From: Kate Giddings
Sent: 29 April 2019 17:50
To: Simon Davis <Simon.Davis@arun.gov.uk>
Cc: Anna Appleton <Anna.Appleton@arun.gov.uk>; Planning.Responses <Planning.Responses@arun.gov.uk>
Subject: Y/29/19/DOC

In relation to the ground contamination aspect, I have now read (amongst other submissions) Ground Management Ltd.'s Verification Report (Phases 1-3) (ref.: G6308-04/03, dated April 2019) and would please request that the following queries are addressed:

TITLE: Verification Sample Location Plan

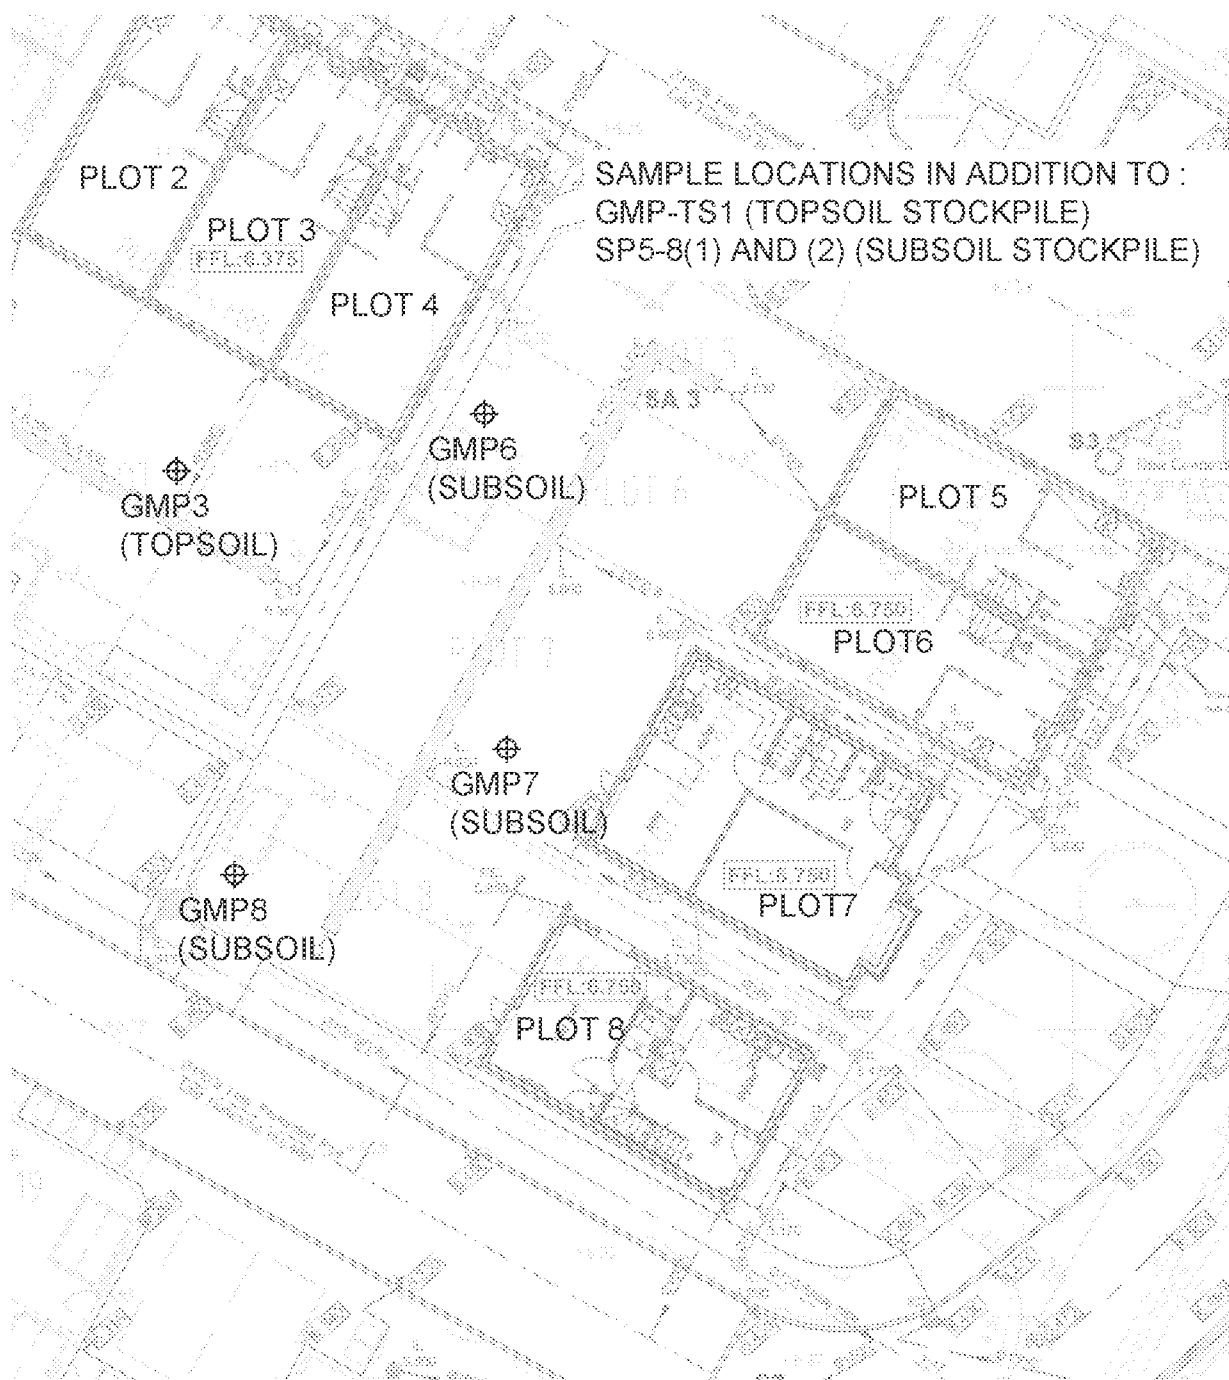
1. since the report was published, has any validation sampling been undertaken for the areas of soft landscaping to the front of plots 5-8?
2. since the report was published, has any validation sampling been undertaken in the area to the north of the site where topsoil placement was to be completed?

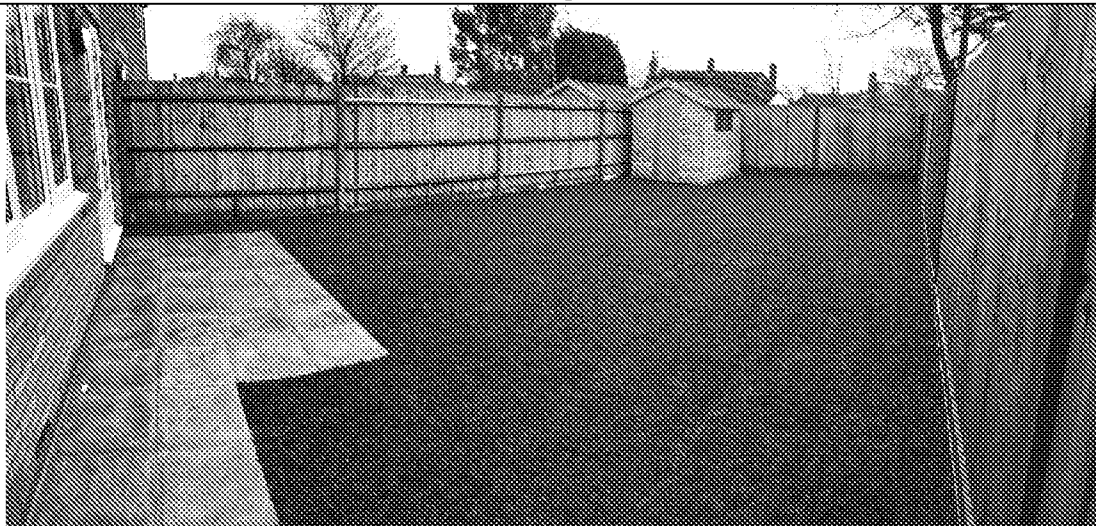
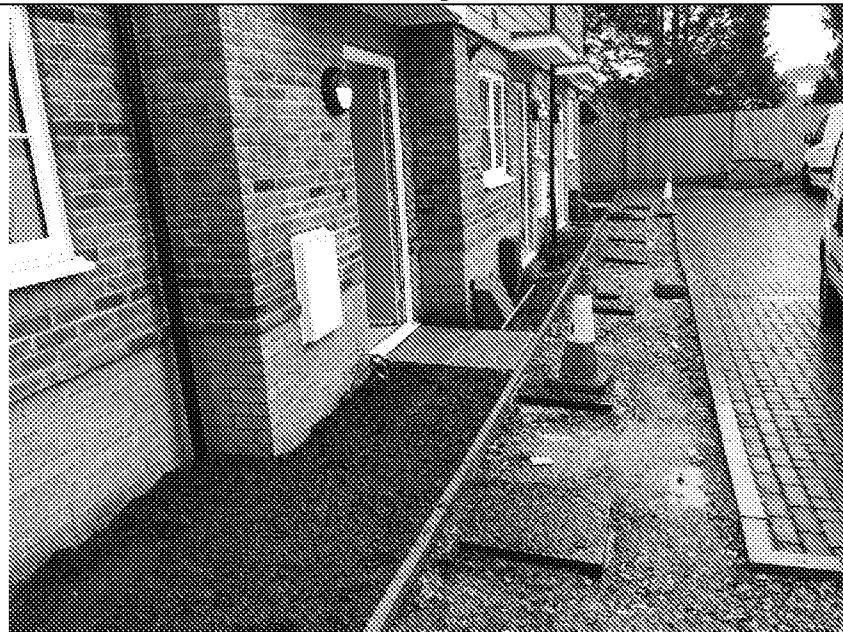
5. please may the photographs provided be made available in colour so that the placement of the geotextile membrane can be identified?
